**Re: Planning Application AW/353/14/PL
11 Marquis Way.**

Re: Planning Application AW/353/14/PL

Planning Application: AW/353/14/PL

project: 11 Marquis Way - Aldwick			
drawing title: Proposed Site Plan			
drawing status: Planning Application			
date: 09 - 12 - 2014	scale at relevant drawing size 1 : 50 (A1) or 1 : 100 (A3)	no: JW131105 - PL10	rev.: -

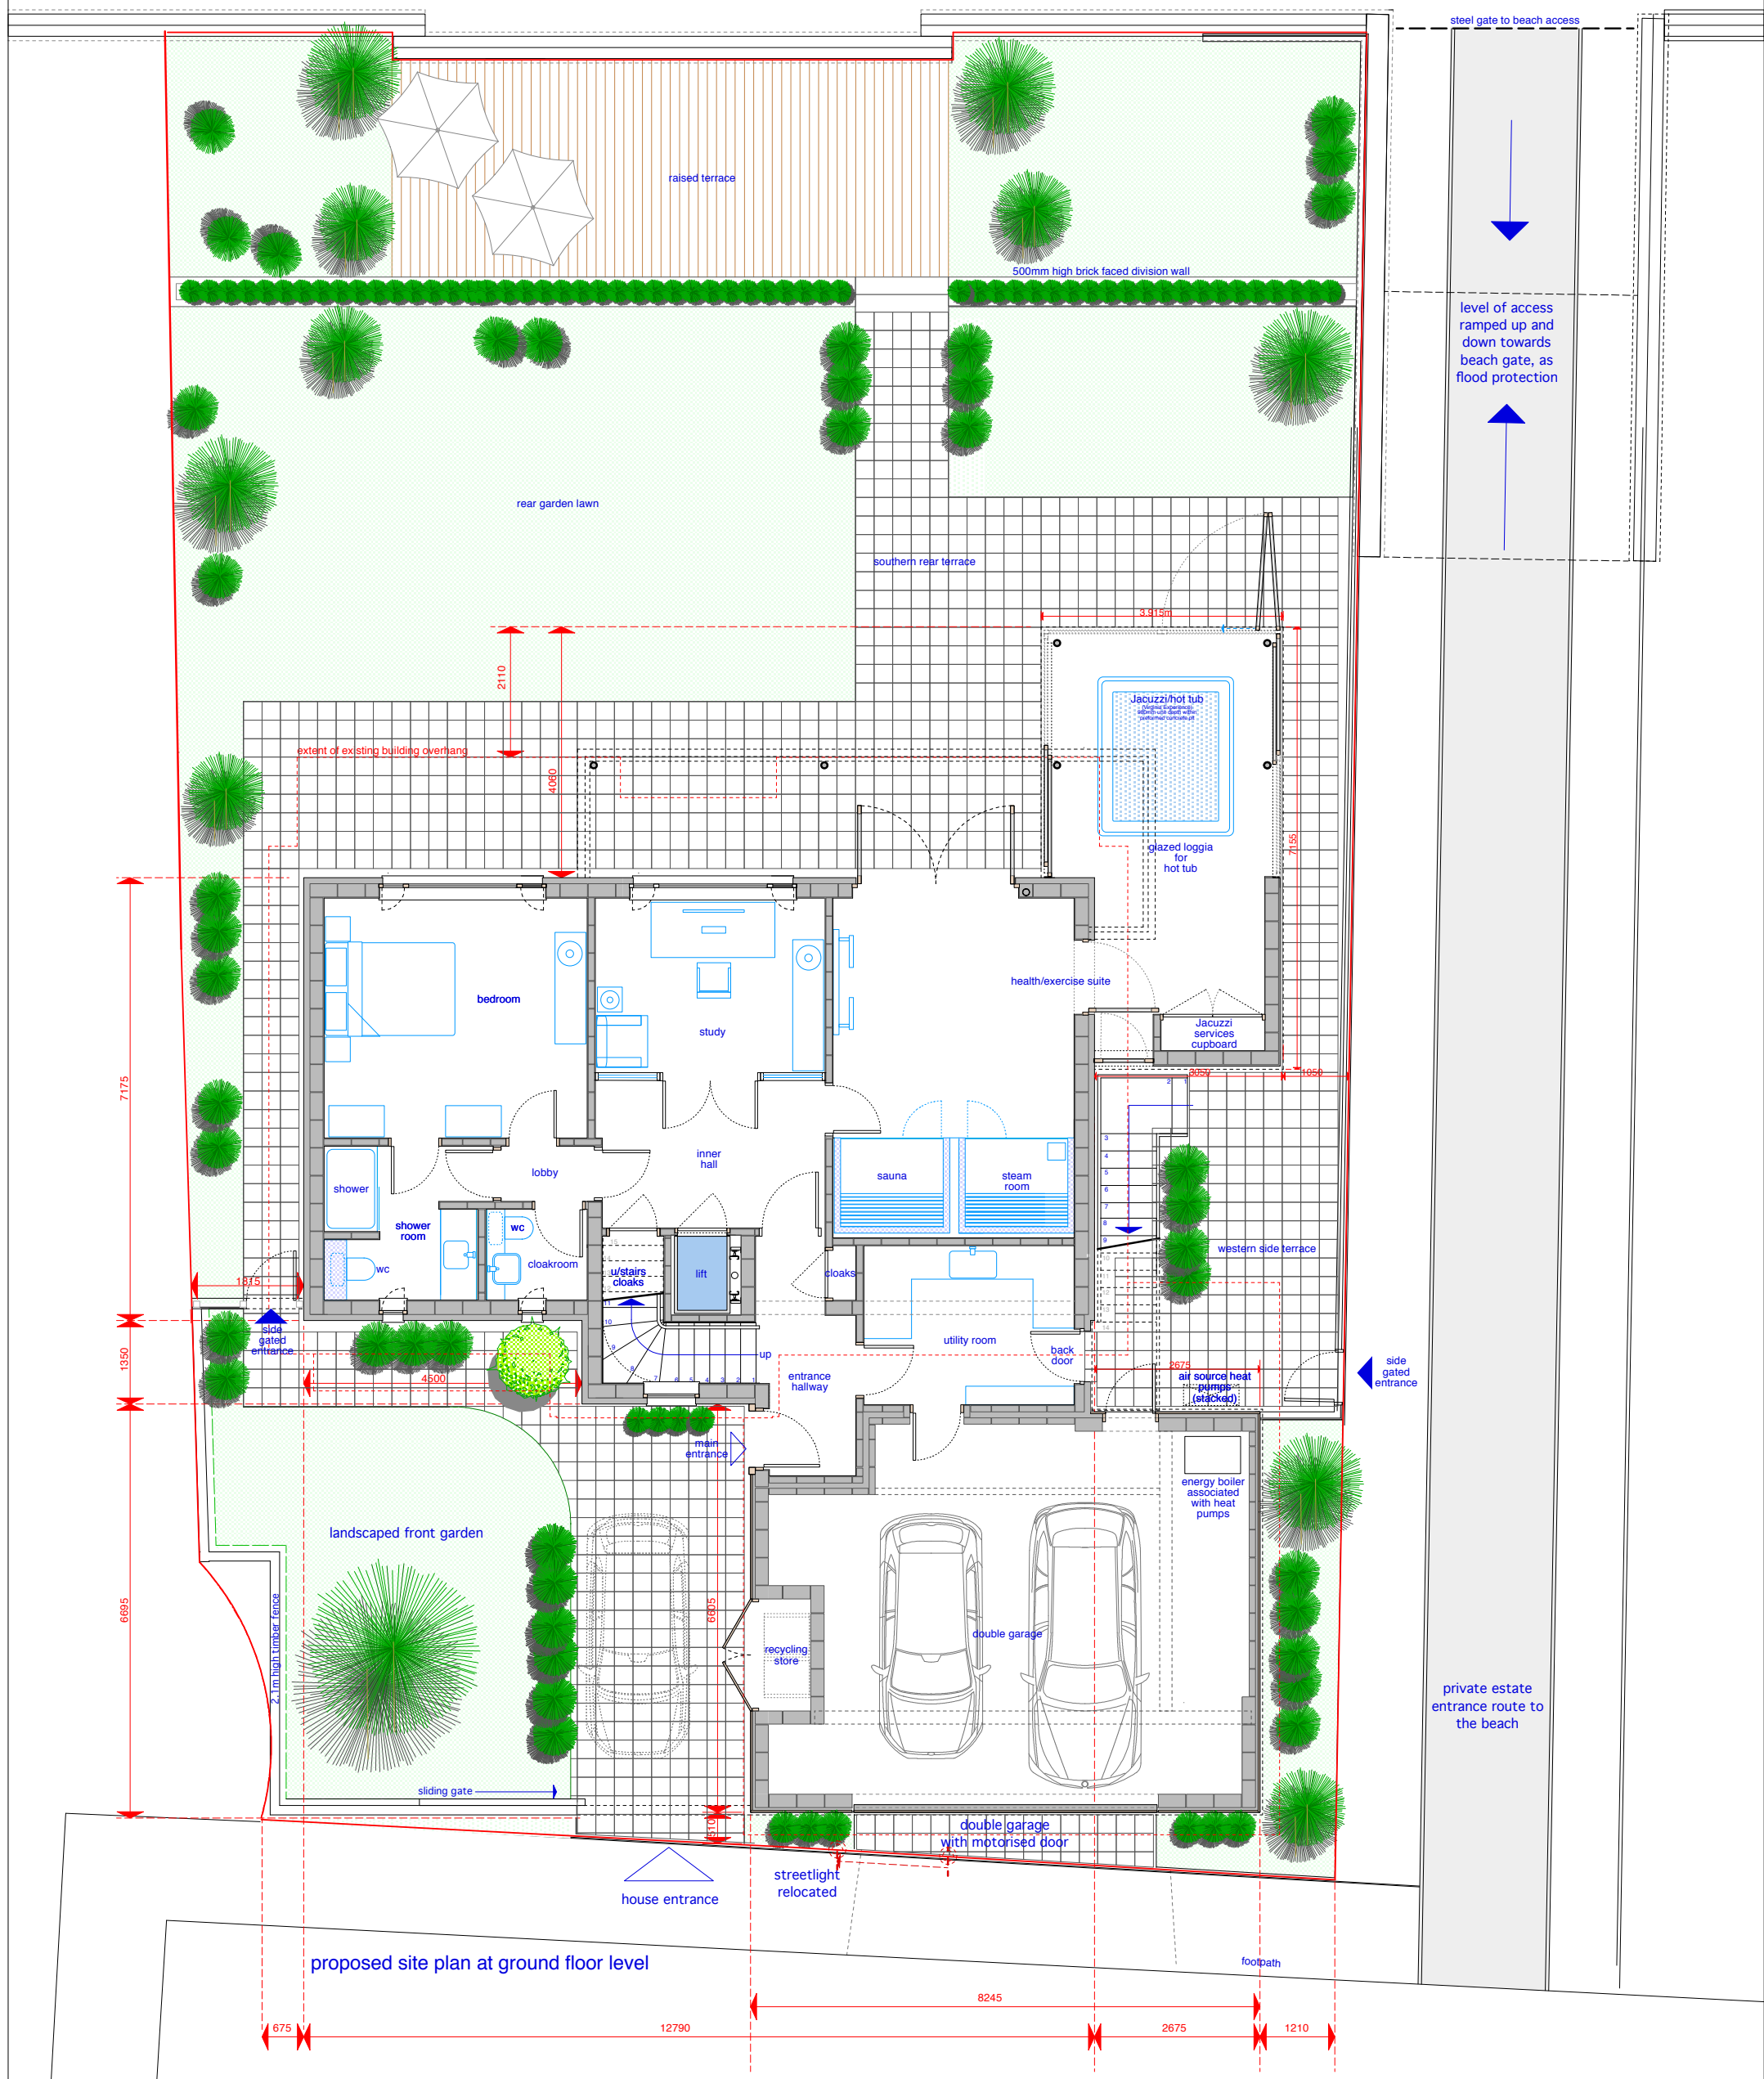
Furthermore, the proposed building will break the existing building line with the additional health & safety concerns of garage doors directly opening onto a pavement instead of a private driveway.

The proposed building will break the existing building line; will have a flat roof at previous peak height, highlighting its non-conformity further. The health & safety concerns of garage doors directly opening onto a pavement instead of a private driveway where the building has been pushed forward to the edge of the plot.

The plans show the development will extend beyond the current building line, on the Southern and Western side.

project:	11 Marquis Way - Aldwick		
drawing title:	Existing and Proposed Parking Plans		
drawing status:	Planning Application		
date:	09 - 12 - 2014	scale at relevant drawing size	1 : 100 (A1) or 1 : 200 (A3)
no:	JW131105 - PL16	rev:	-

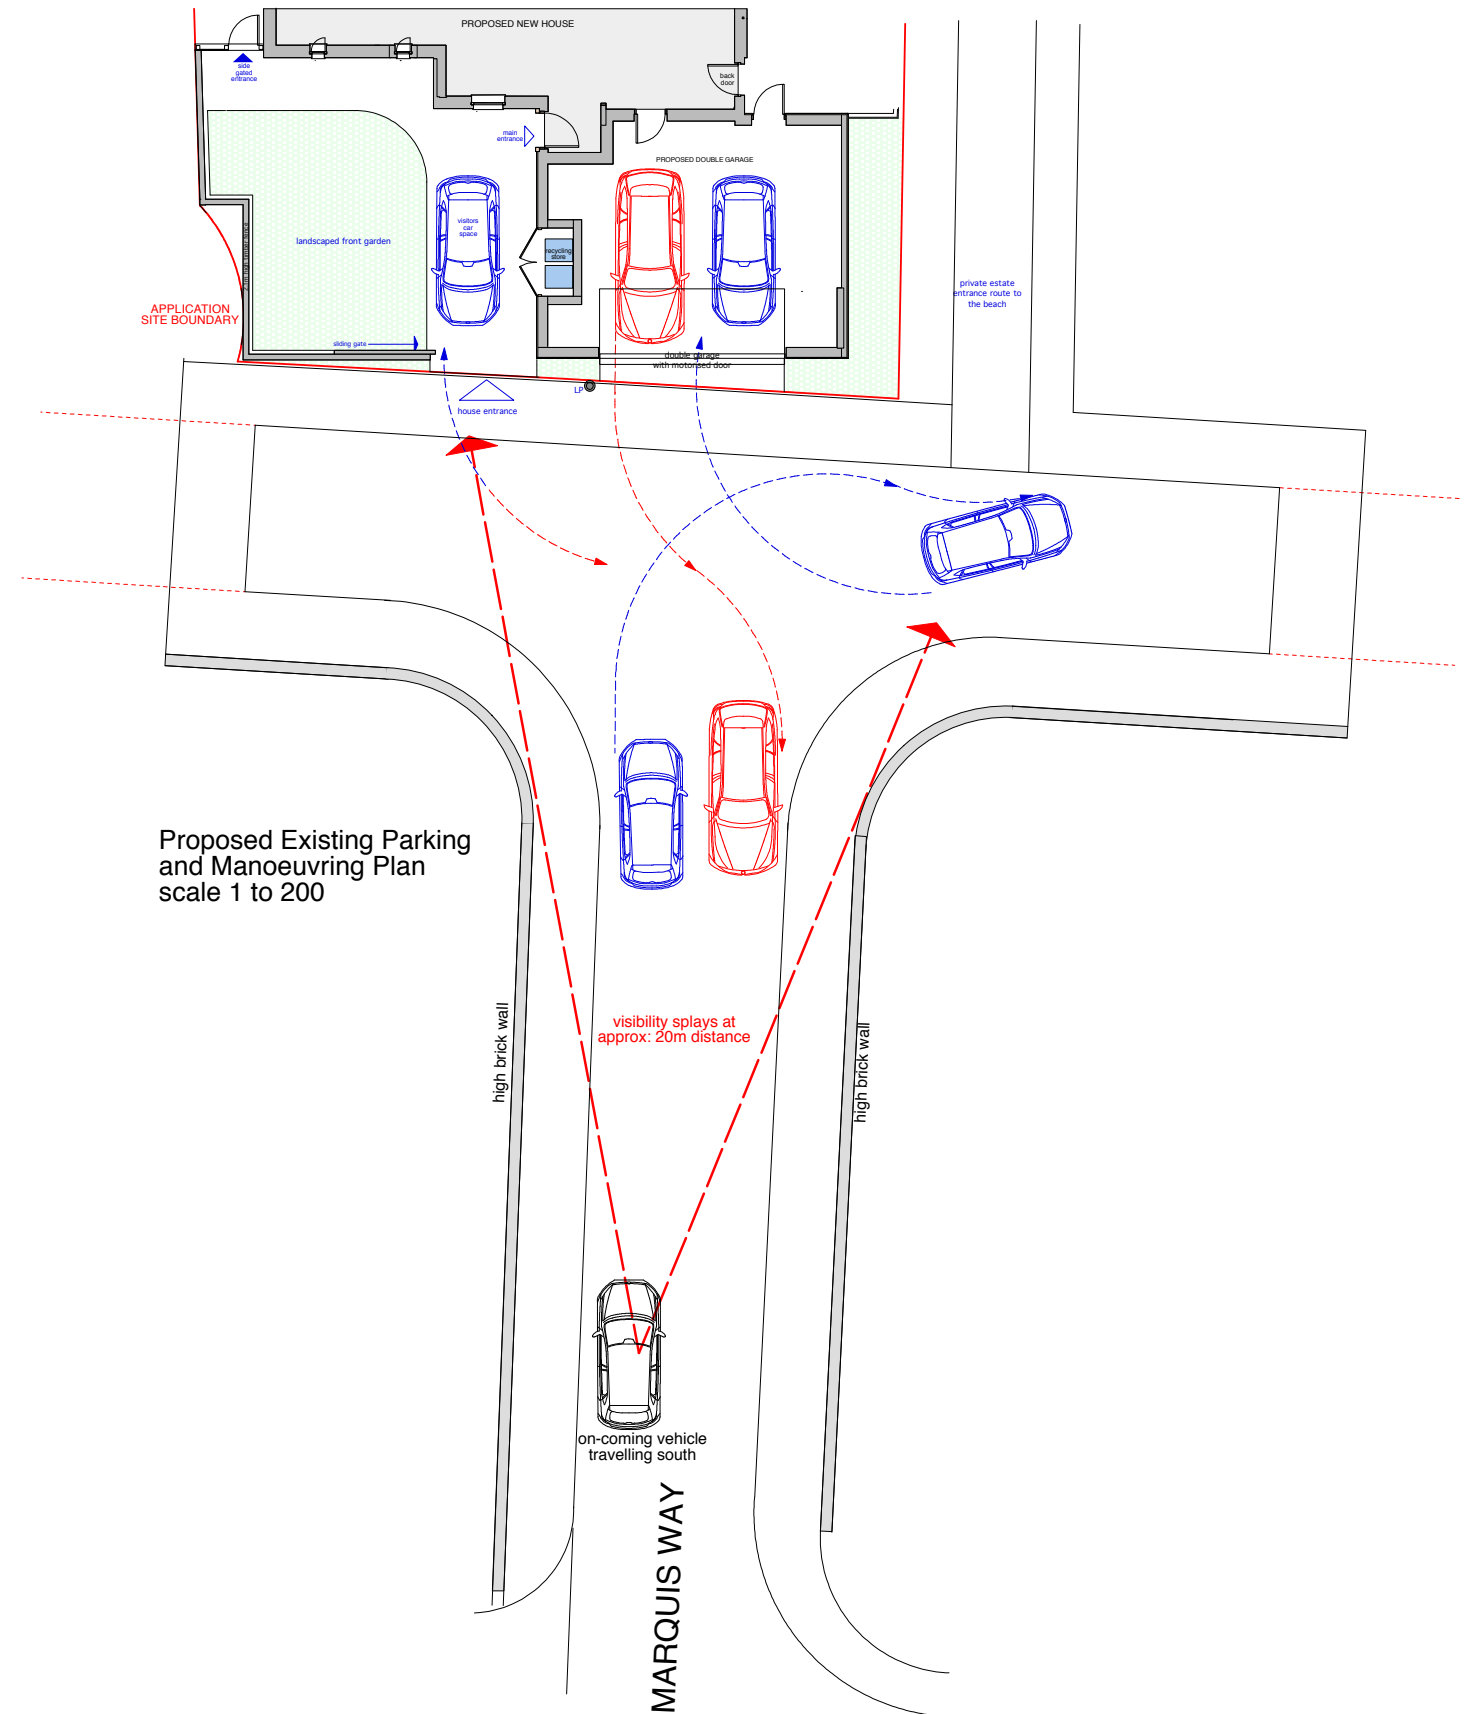
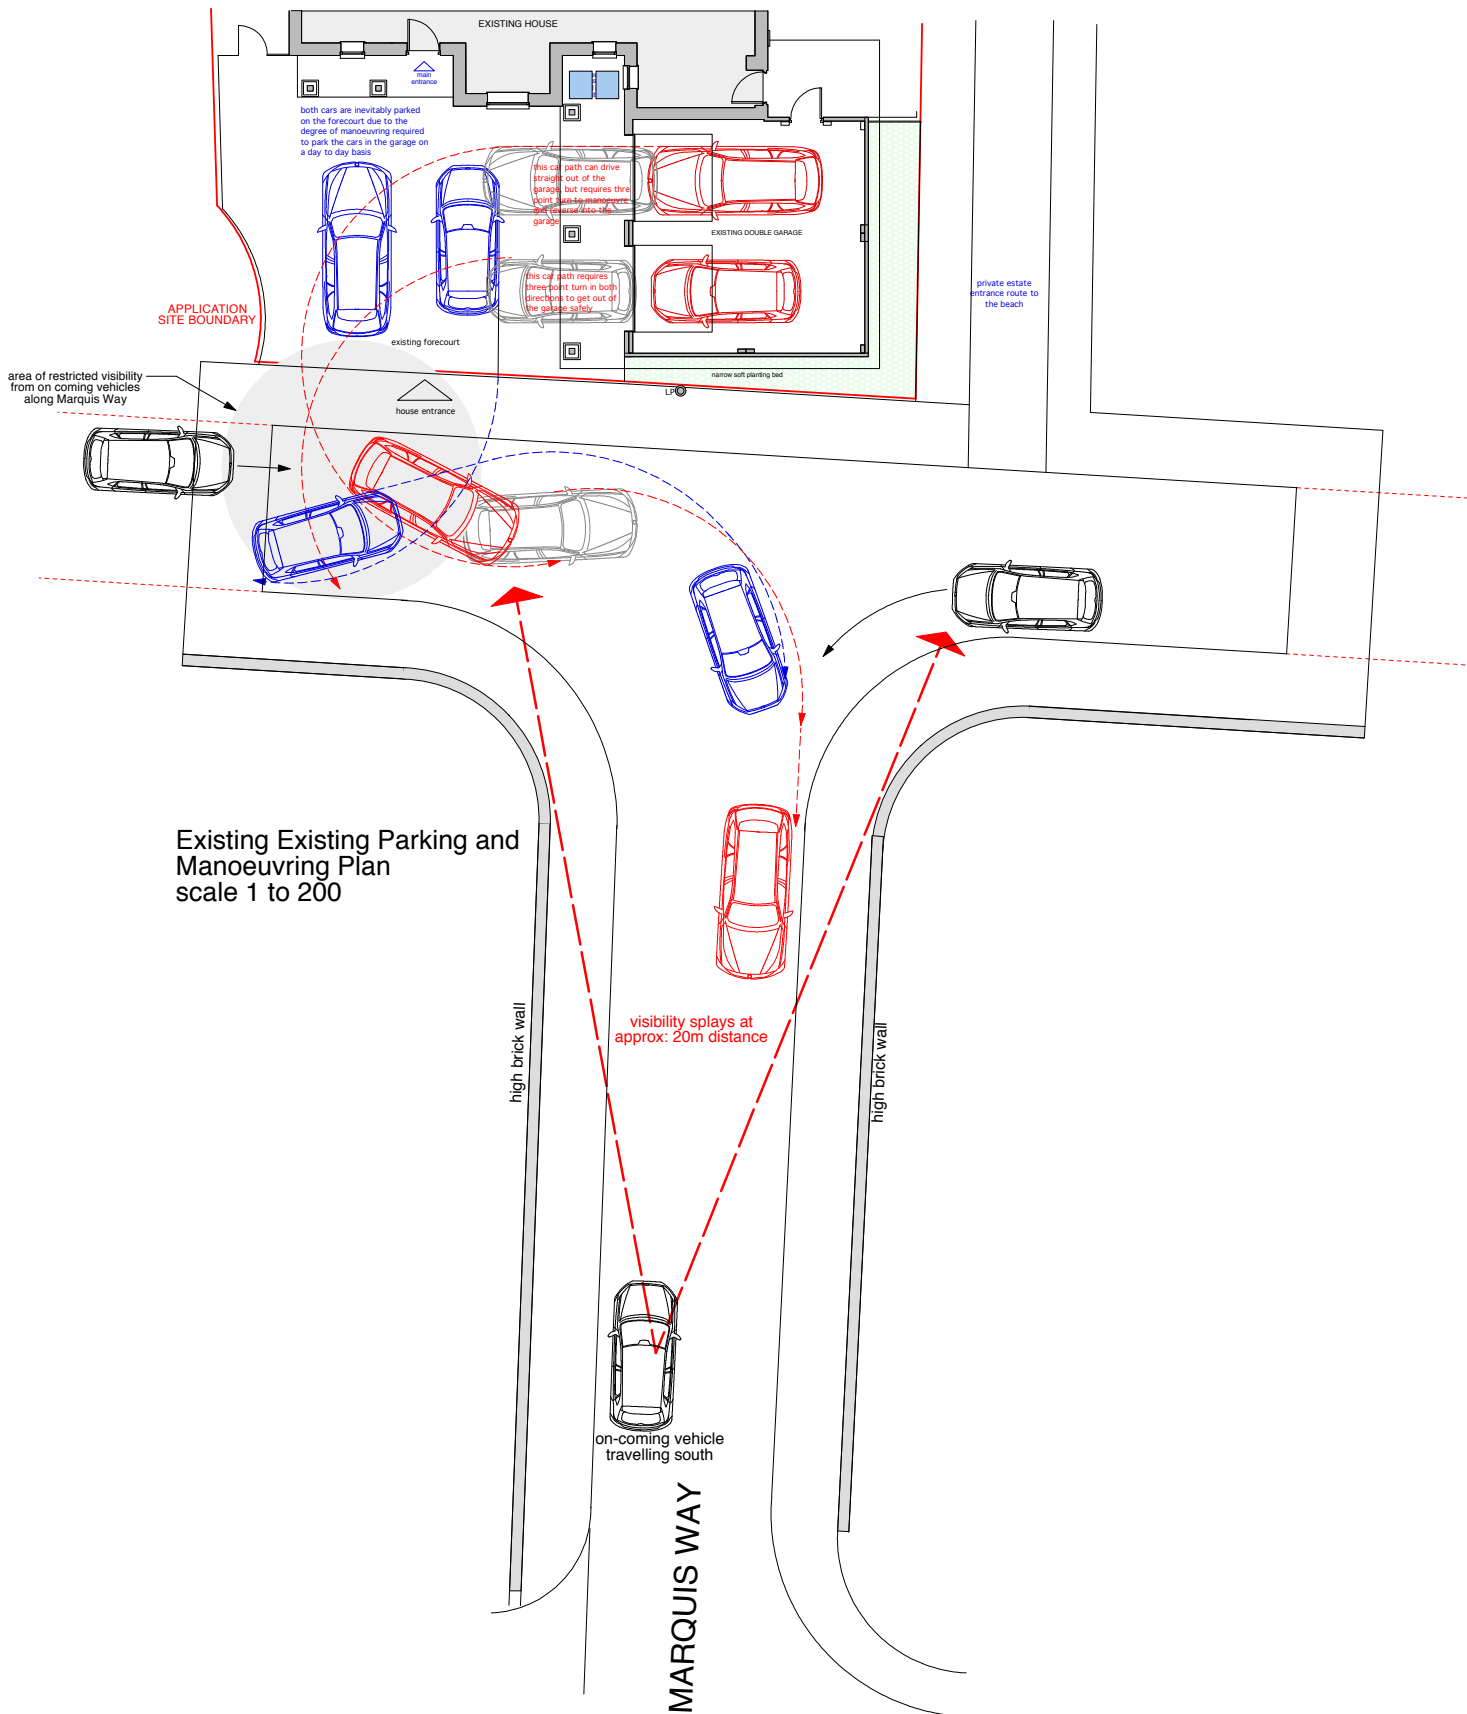
The private road has not been built to a standard which would be adopted by the Local Authority. The heavy vehicles used in demolition and construction are likely to have a deleterious impact upon the properties adjacent to the road, with potential for disturbing their foundations and unacceptable damage to the fabric of the road. The road is narrow and will restrict manoeuvring - presenting a real danger to residents whether as pedestrians or in vehicles.

project:	11 Marquis Way - Aldwick		
drawing title:	Proposed Sections A and B		
drawing status:	Planning Application		
date:	scale at relevant drawing size	no:	rev:
09 - 12 - 2014	1 : 50 (A1) or 1 : 100 (A3)	JW131105 - PL19	-

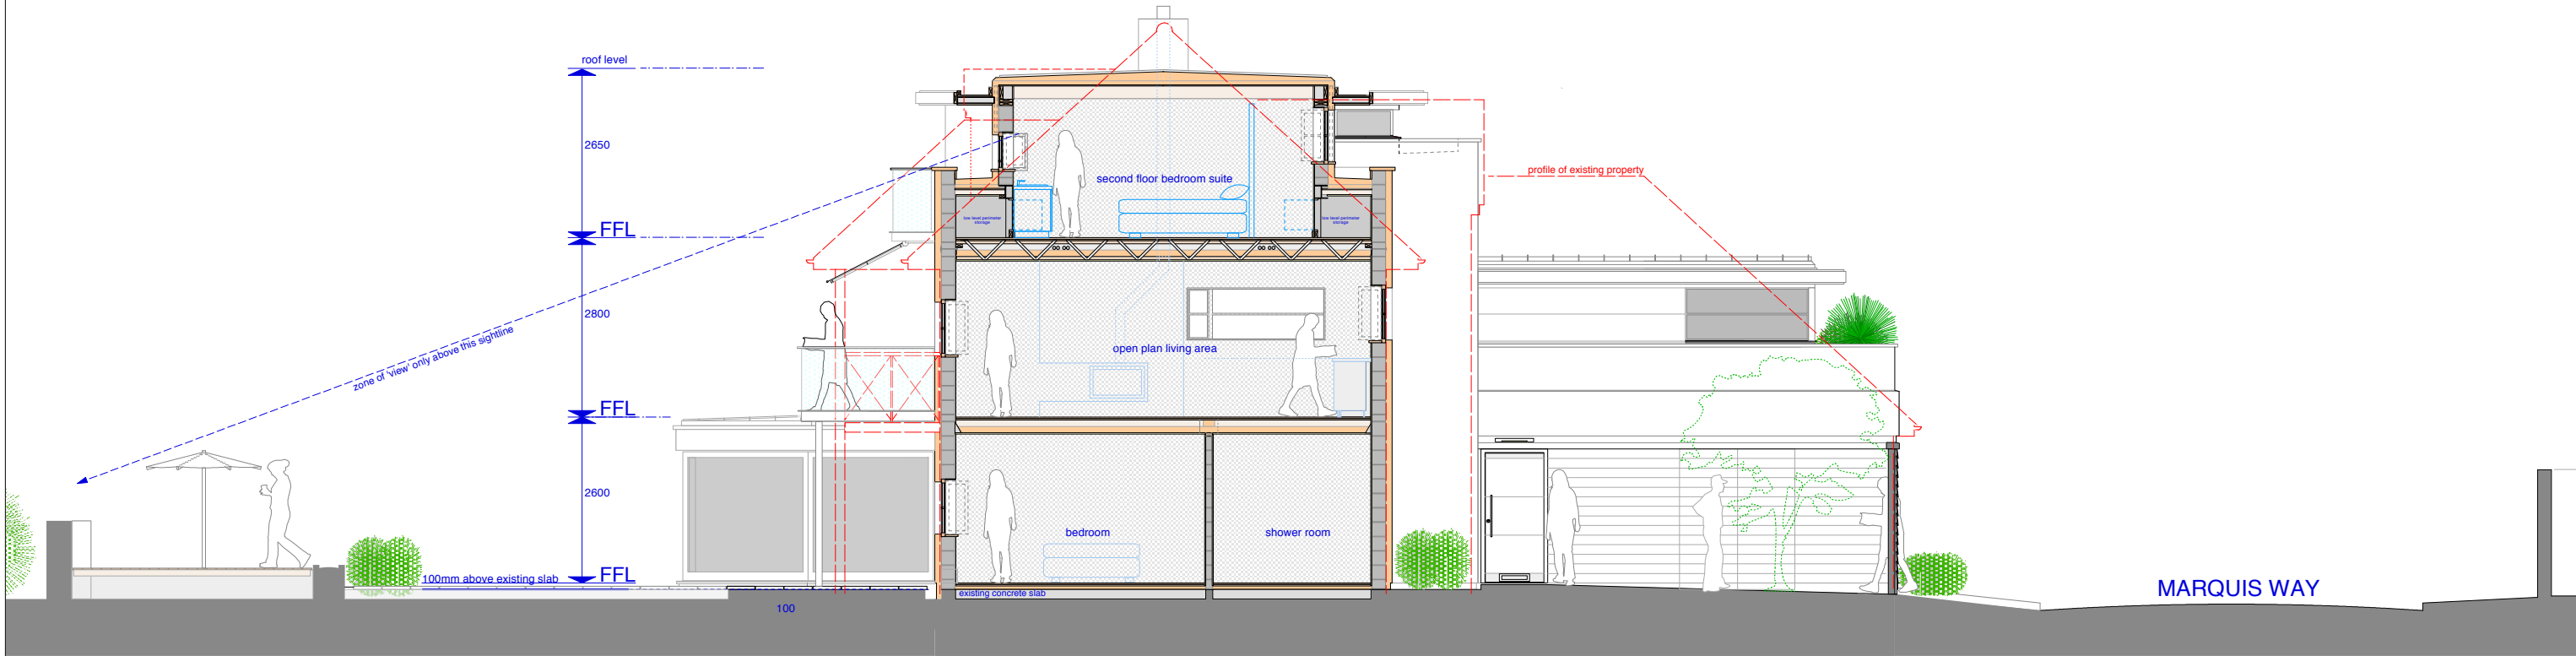
My objection to this development is based on its impact on surrounding properties, given the manner in which it contrasts with the overall design of houses in the estate, and its use of surround balconies which in effect, overlook most of the properties in the top two rows near the beach.

Current houses on the estate have all been carefully designed in traditional and complementary materials, with careful attention paid to minimising the extent to which they overlook each other. My view of number 11 from my living room is currently limited to its garage roof, but under the proposed new development this would change to a view of the north and west balconies. This suggests conversely that they would then be able to see into my living room from these points.

The plans show a property out of keeping with the remainder of the estate. The new property will have white rendered finish to part of it, a flat roof and balcony to its front and side which is in marked contrast to the all brick construction and pitched tiled roofs on all the properties (including the one in question as it is pre-development). The other 5 houses on the front have south facing balconies only. I note that 2 other properties within the road have had extensions (agreed at Planning) which are sympathetic to the character of the road.
